Comments re Planning Application 2020/91092 re land adj to 81 Common End Lane

Drawing
Proposed Site Plan

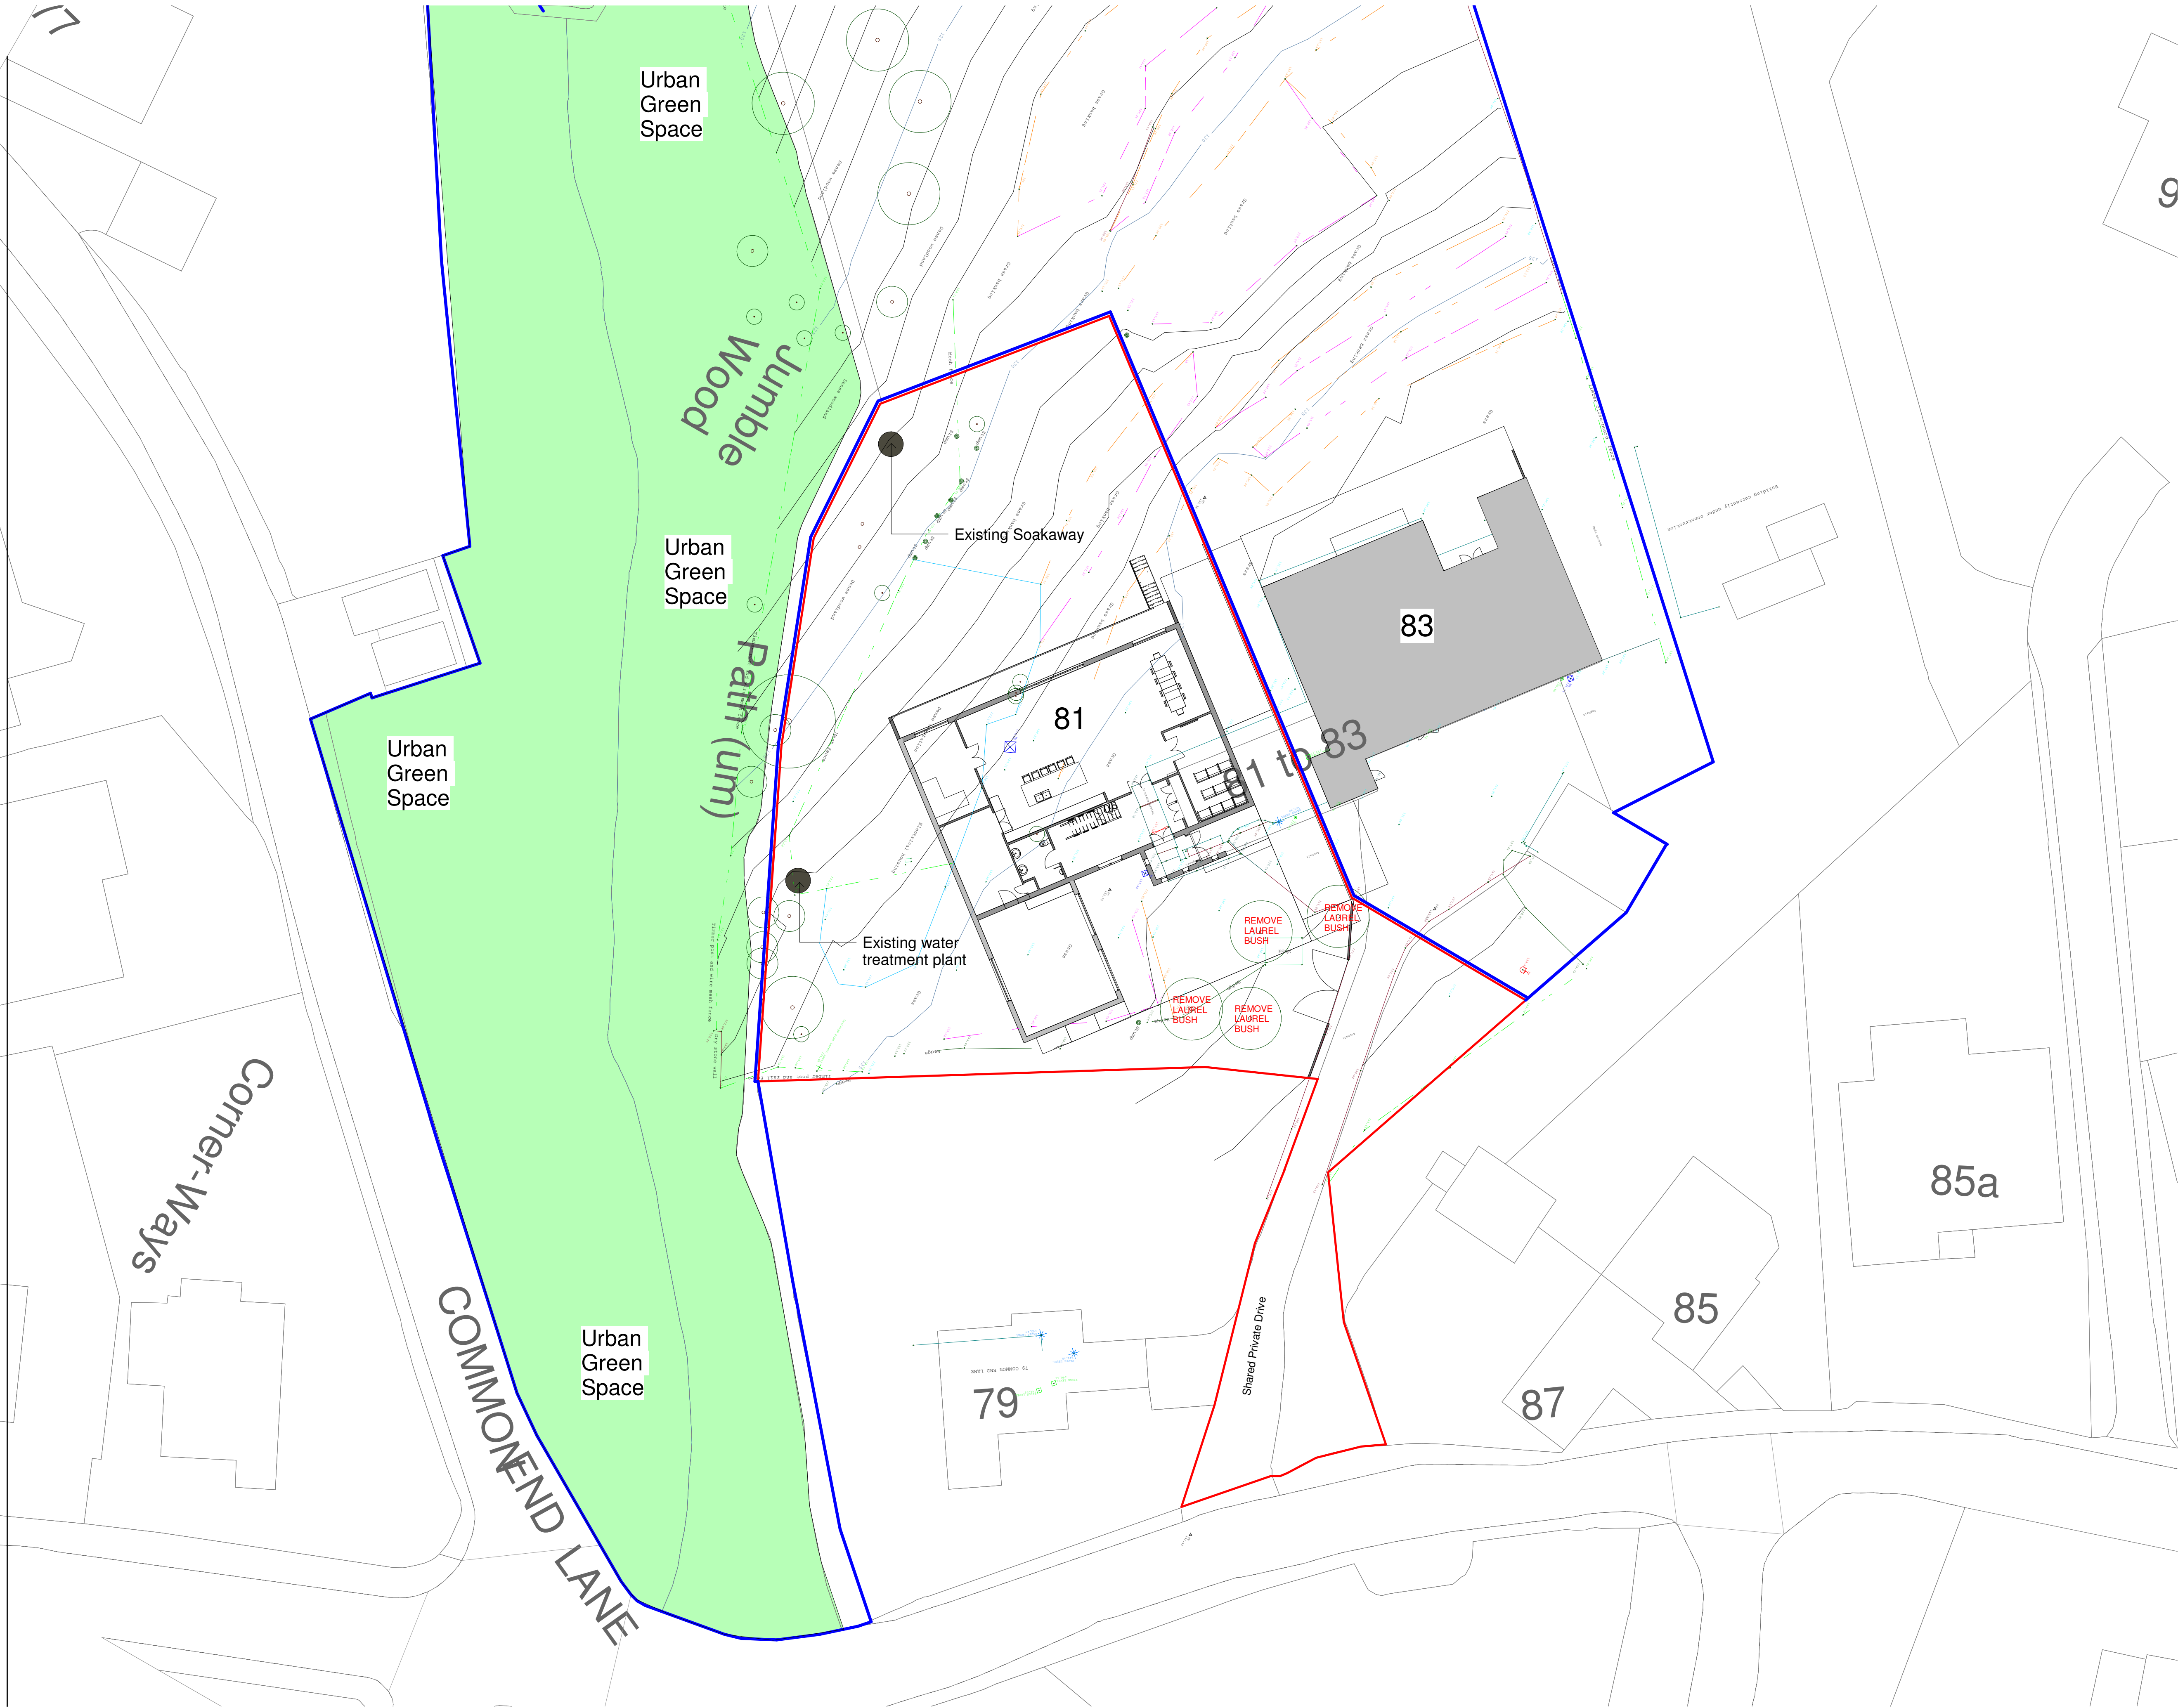
2. There appears to be little or no dimensions to the plans (other than a site area of 1500sqm) so it is difficult or impossible for us to assess almost anything.

2.1. Please request many additional dimensions to be added to all plans; sections; elevations and perspectives so we can accurately assess the impact upon our home?

2.3. Our rights of view will be seriously impacted but without dimensions we cannot ascertain this - please provide more dimensions?

2.5. We would request site wide sections and also 3D perspectives showing the relationship to our home and land as well as all surrounding properties, highlighting particularly the main reception room and bedrooms relationship to our reception rooms and bedrooms?

2.6. It is crucial for the application to provide a site section to provide proof the minimum view to view distances both on the horizontal (21m) and incline (24m) and also the view to side distances too?

2.7. The proposals house location and ridge height will impact severely upon the beautiful view we have enjoyed of Castle Hill from our patio area:-
